SURREY COUNTY COUNCIL – RESPONSE TO ExQ1 C.A.1.40

19 April 2024

GATWICK AIRPORT NORTHERN RUNWAY PROJECT DCO

PINS Reference: - TR020005

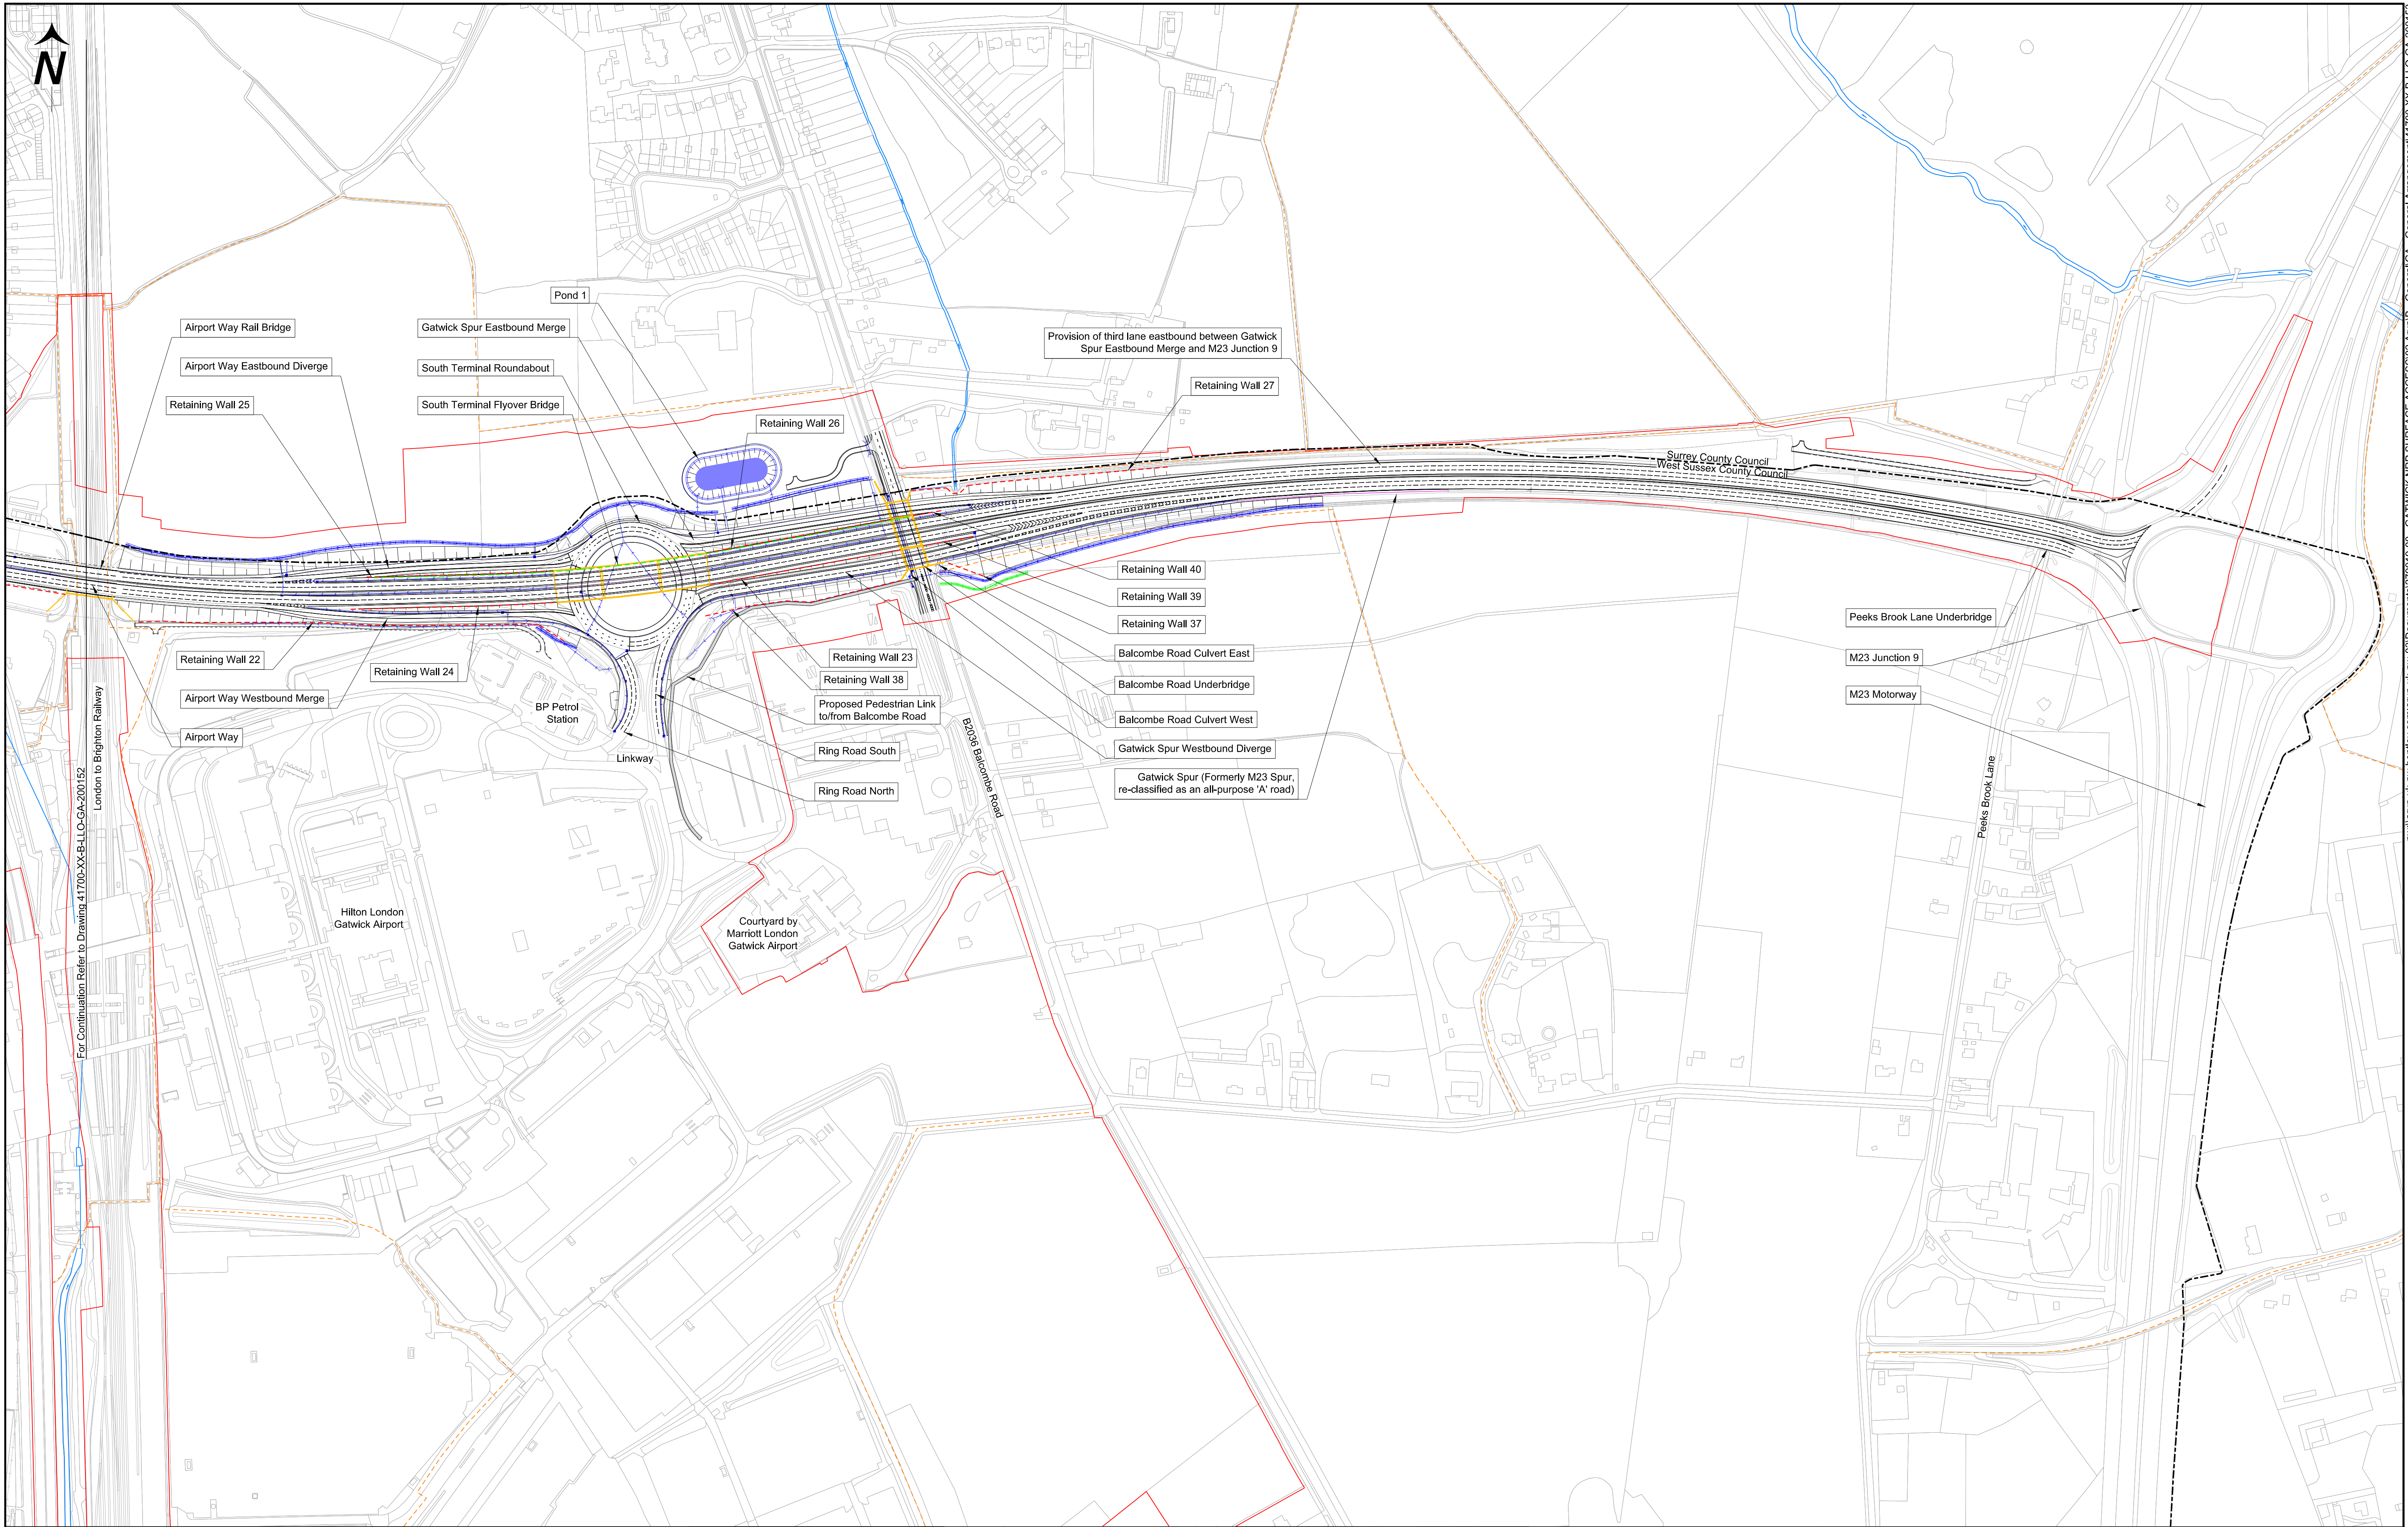
1.9. Further detail of the new layout arrangements are set out in the Surface Access Highway Plan 41700-XX-B-LLO-GA-200153 – (extracted below) and which should not be approved without further amendments reflecting the mitigation required.

- 1.11. The above temporary and permanent works shown in the above surface access arrangement plans are set out in detail in Work No. 35 in the draft DCO. SCCaL considers that the mitigation necessary to meet its concerns would include amendments to these plans and Work No. 35 is amended to enable a permanent access arrangement to be included within the DCO into Bayhorne Farm as part of the Project. The ExA is asked to require the Applicant to work up proposals in consultation with the SCCaL at the earliest opportunity, so that if a change request is needed, it can be accommodated within the examination timetable.

- 1.14.2. The relevant surface arrangement plans and other plans and application documents are amended to show the permanent access on a new alignment and that the new alignment is agreed in advance with SCCaL prior to issue;

Figure 103. South Terminal Junction Improvements Indicative Plan

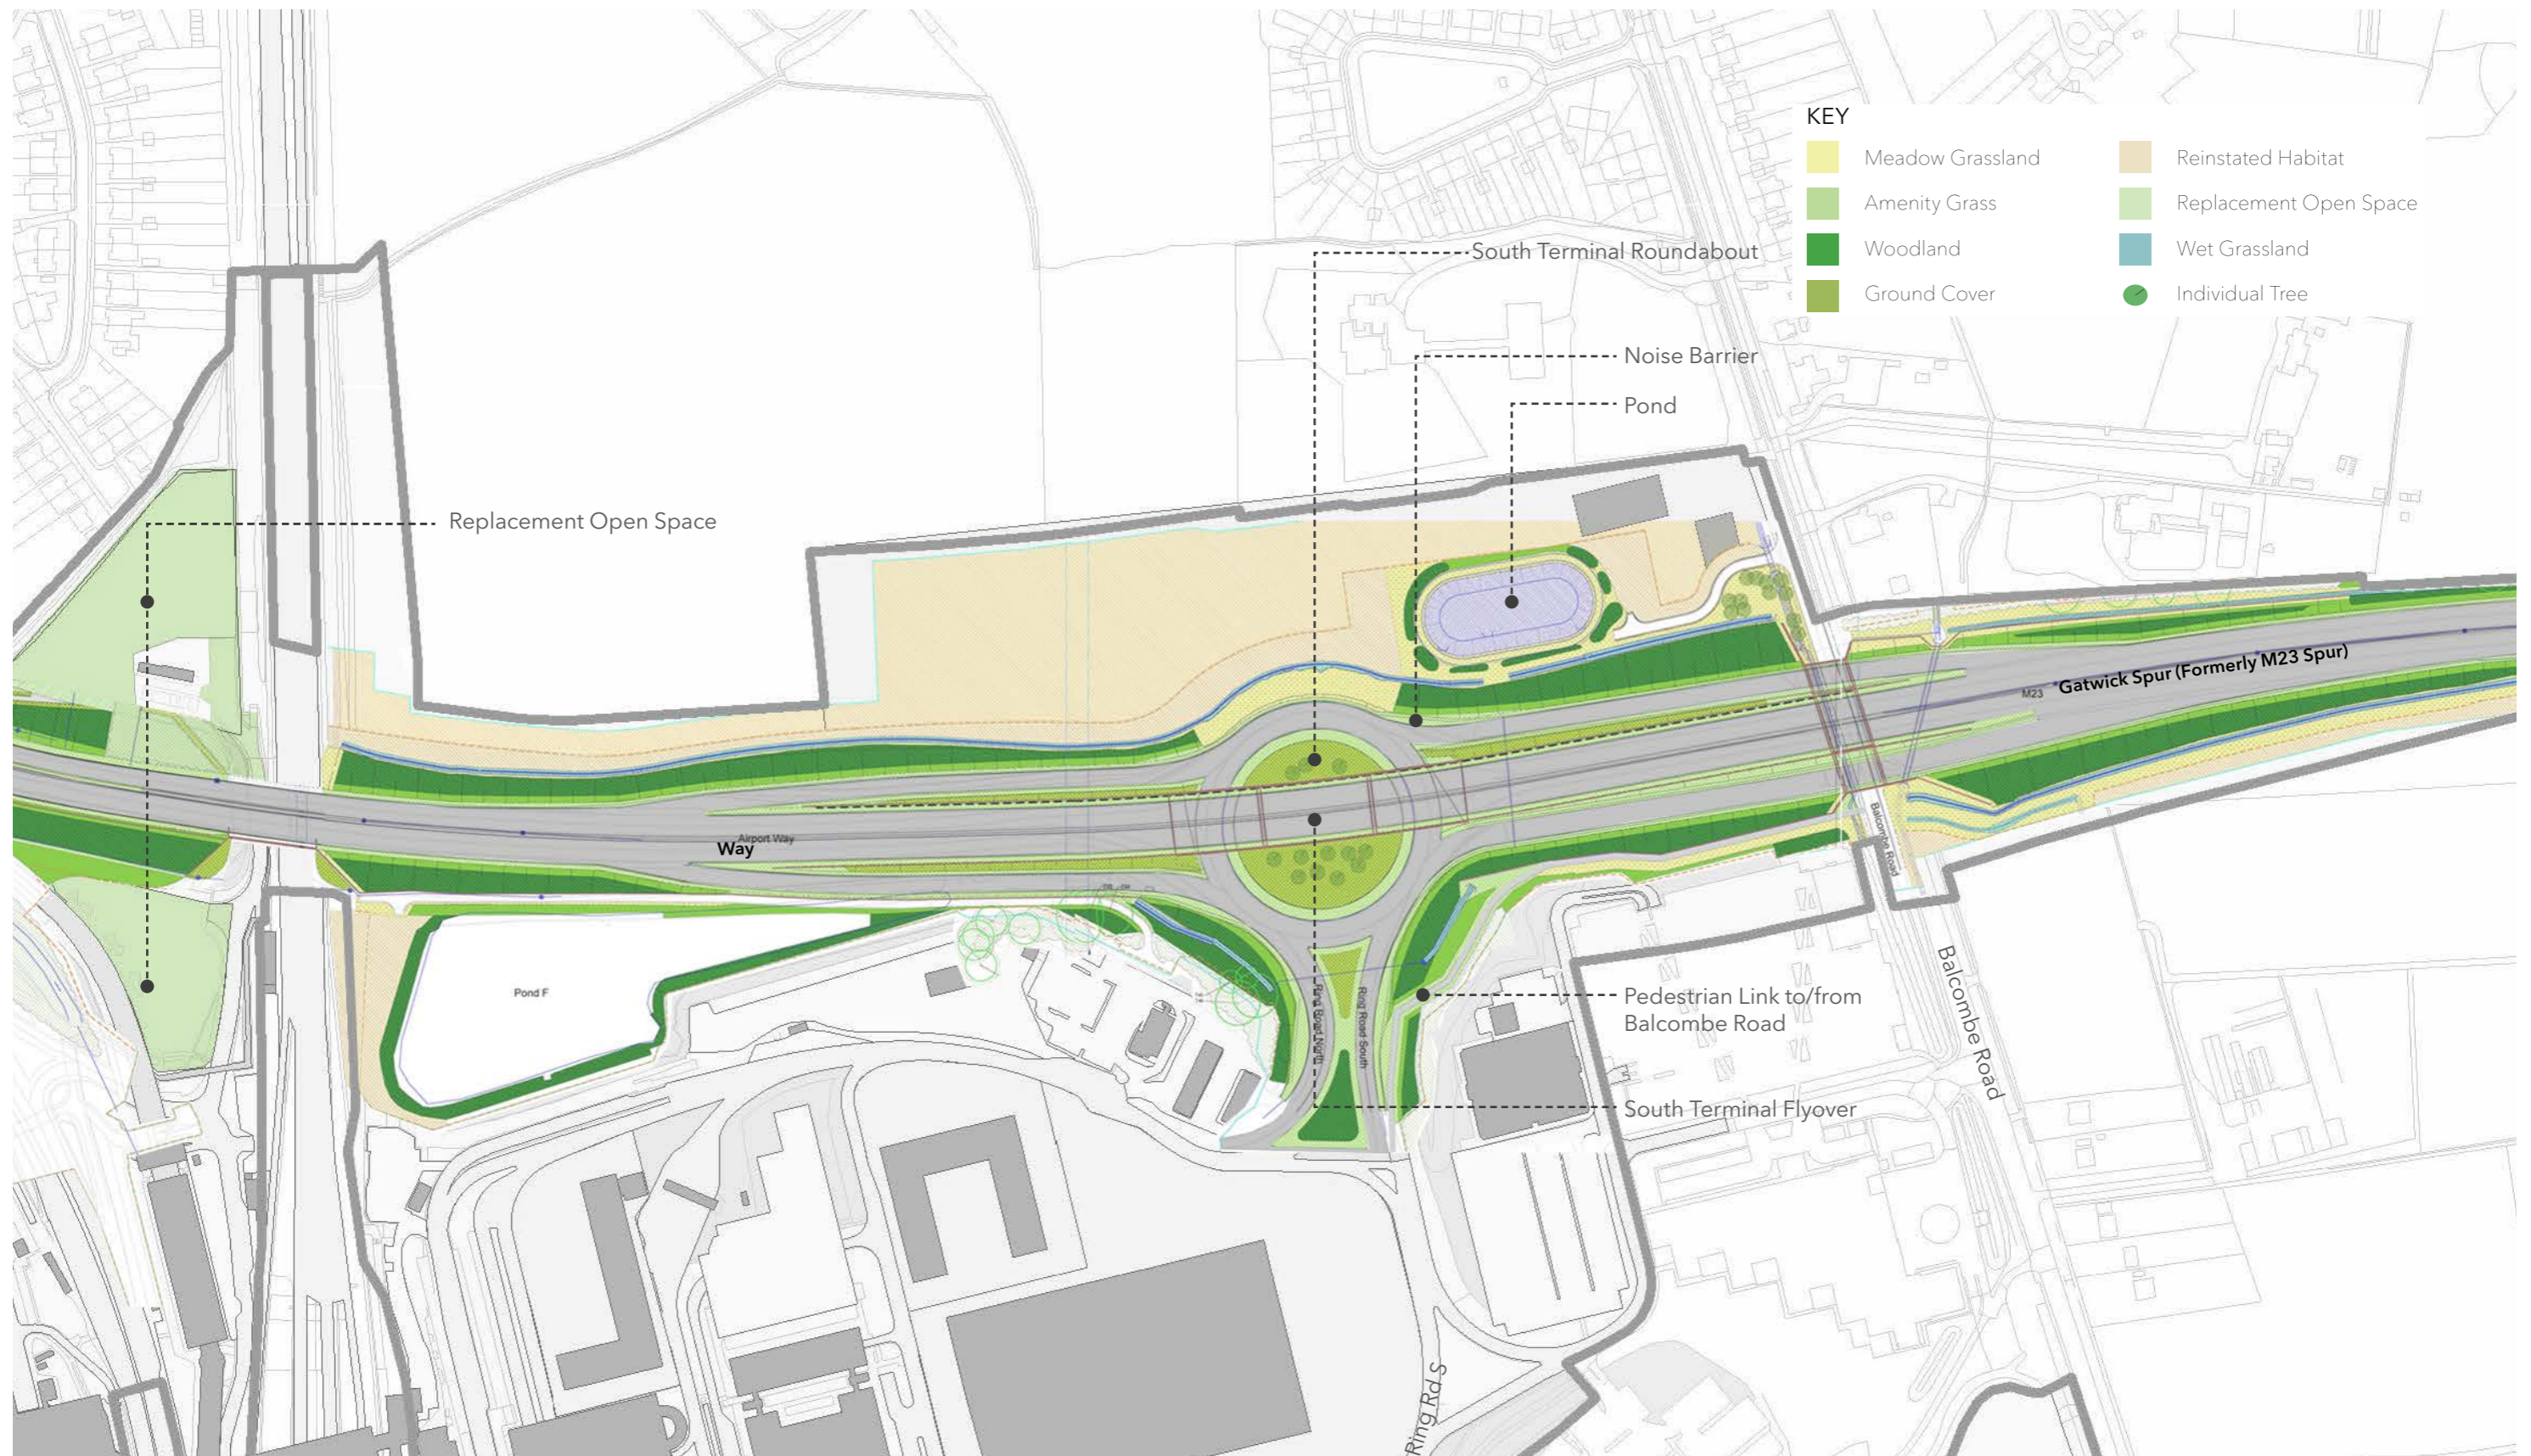
1.10. At paragraph 8.3.8 “South Terminal Roundabout Contractors Compound” in the Design and Access Statement (Volume 5), the proposed temporary works to take

access from STR and form a temporary access road into the compound are shown – an extract of the proposed layout is shown below:
